MP10_0023 MOD 1 Bulk excavation and basement car parking
MP10_0025 Commercial building C4
MP10_0048 Barangaroo Headland Park
MP10_0087 Remediation pilot trial

Executive Director
Maritime Property Strategic Development

**GENERAL ARRANGEMENT SITE PLAN**

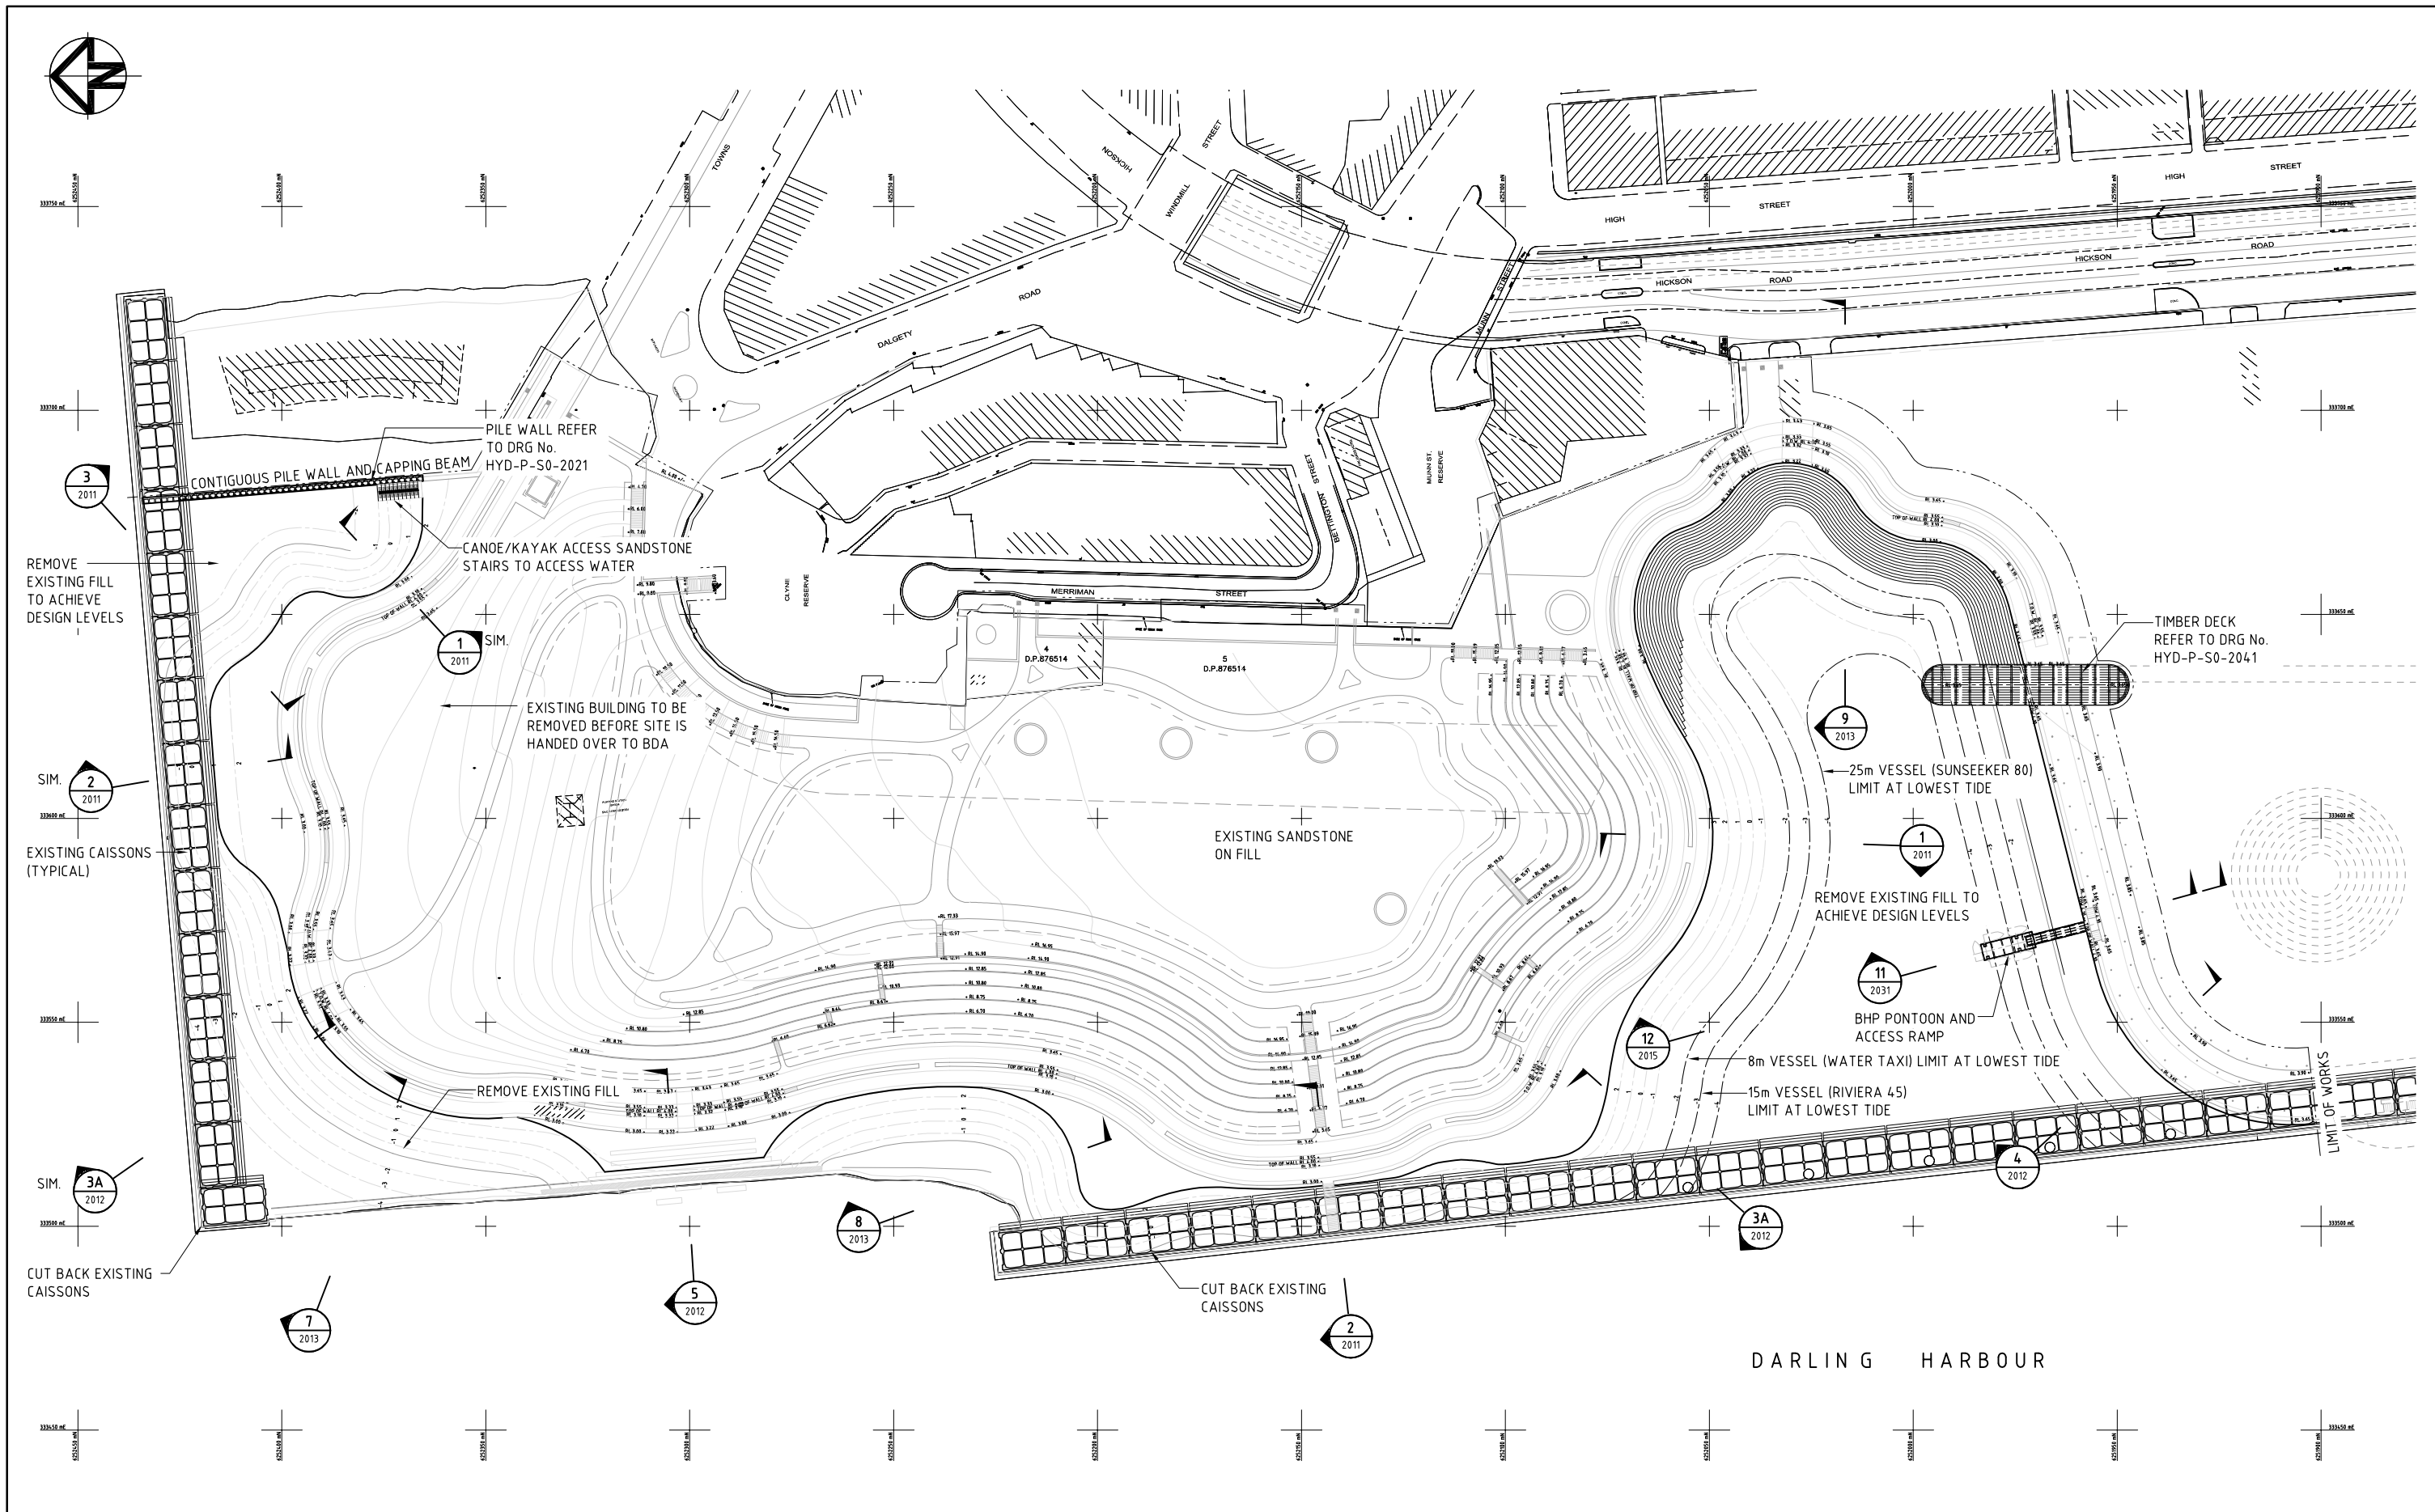
NSW Maritime has no objections to these proposals. However, we have some concern over the design of the Northern Cove, as set out in MP10_0048. Based on the PA documentation, the depth throughout the cove is unclear - it would be preferable to maintain a sufficient depth to allow some navigation throughout this area. There is potential to provide further protection for the cove through building out part of the shoreline. Cutting the existing caissons to just below the low tide level, rather than the bed level of the cove itself, also has the potential to cause a significant navigation hazard and should be reconsidered.
